Application no: H23-0586-10

Description: Details of affordable housing and roadside gullies (Conditions 3 and 9 of H23-0973-09)

Location: Cobgate
Whaplode
Spalding
Lincs

Amendment: Revised layout showing trench soakaway
(dwg. no. 1006/01-G)

DRAWING No:
1006/01-G

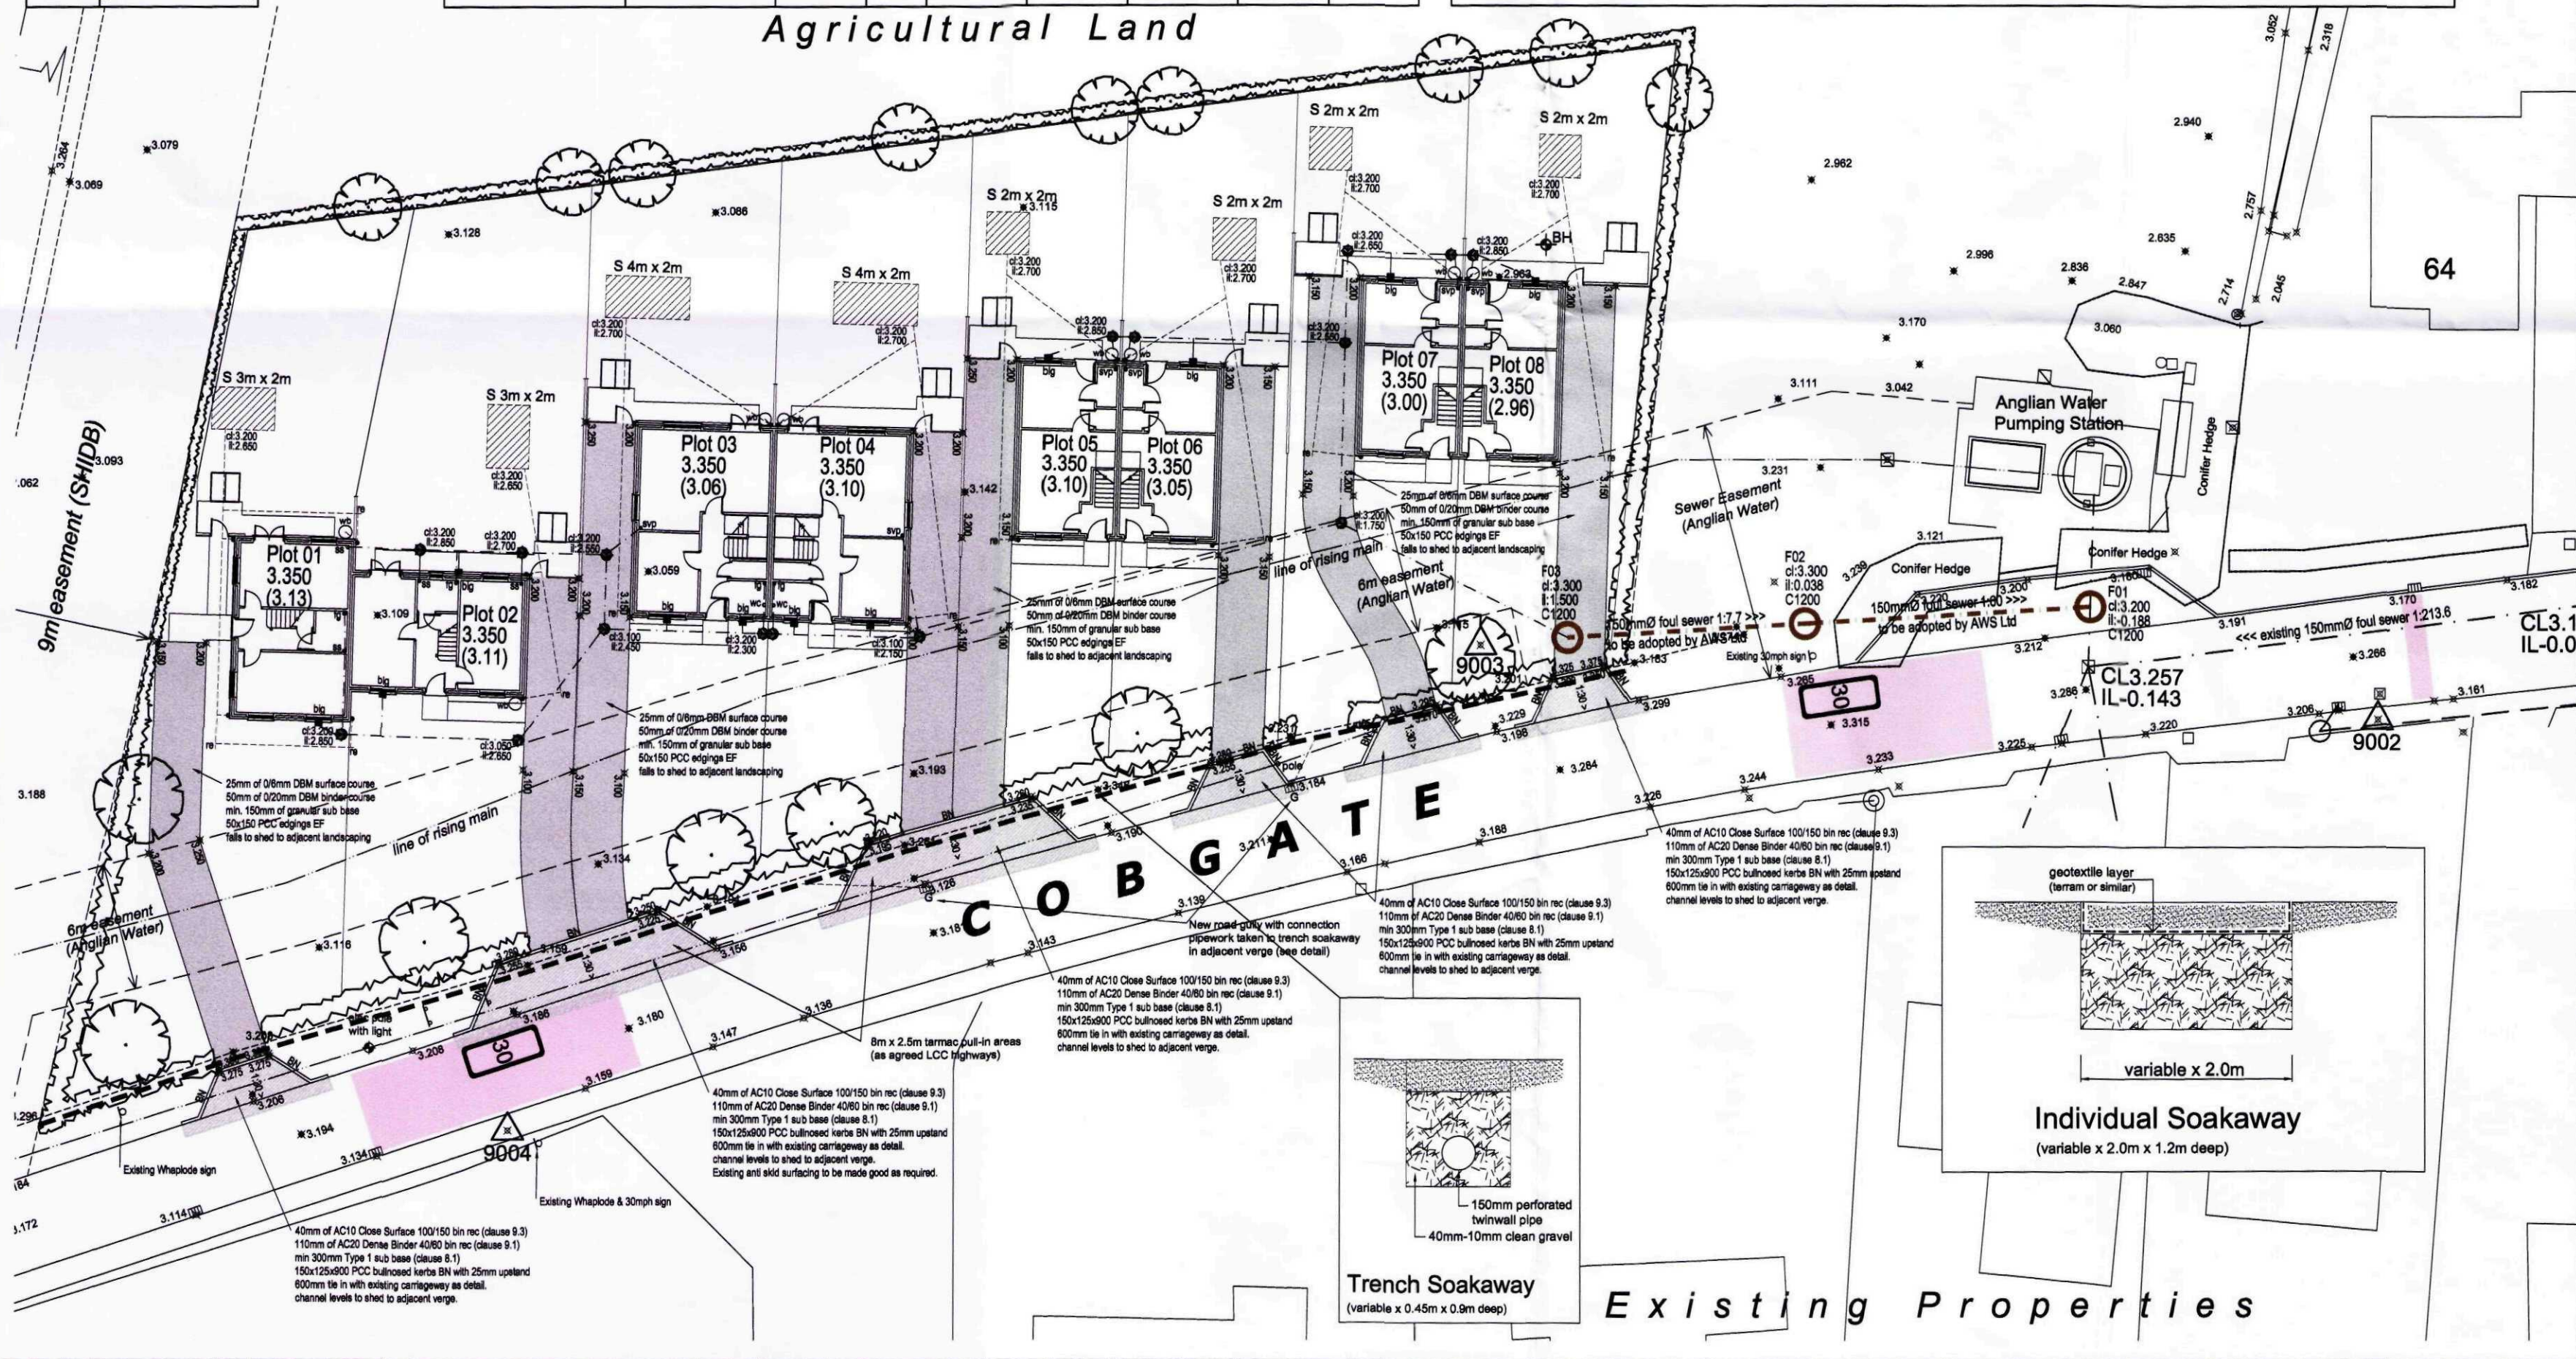
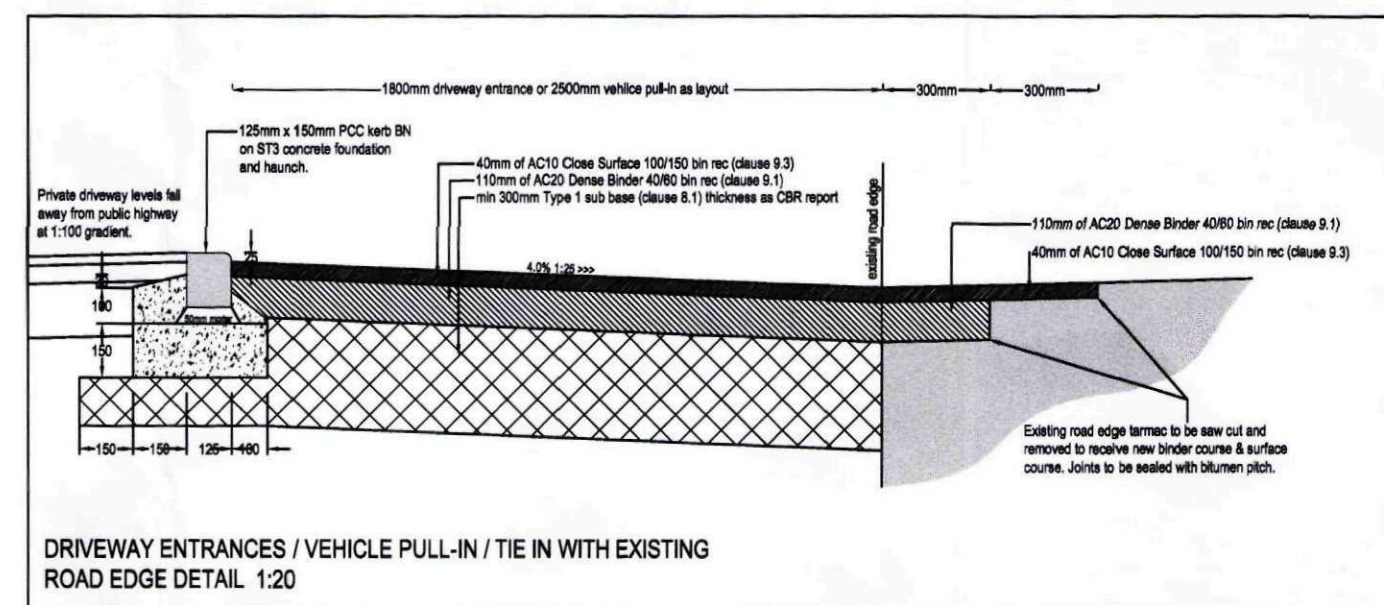
I emailed you 13/10/10 with rev G of the layout for the above showing the requested trench soakaway detail for the gullies on Cobgate.

I can confirm the details shown on your Drawing No. 1006/01-G are acceptable to the Highway Authority. I have copied this to Alan and Richard so that hopefully the Condition Compliance for the Planning Consent can be signed-off.
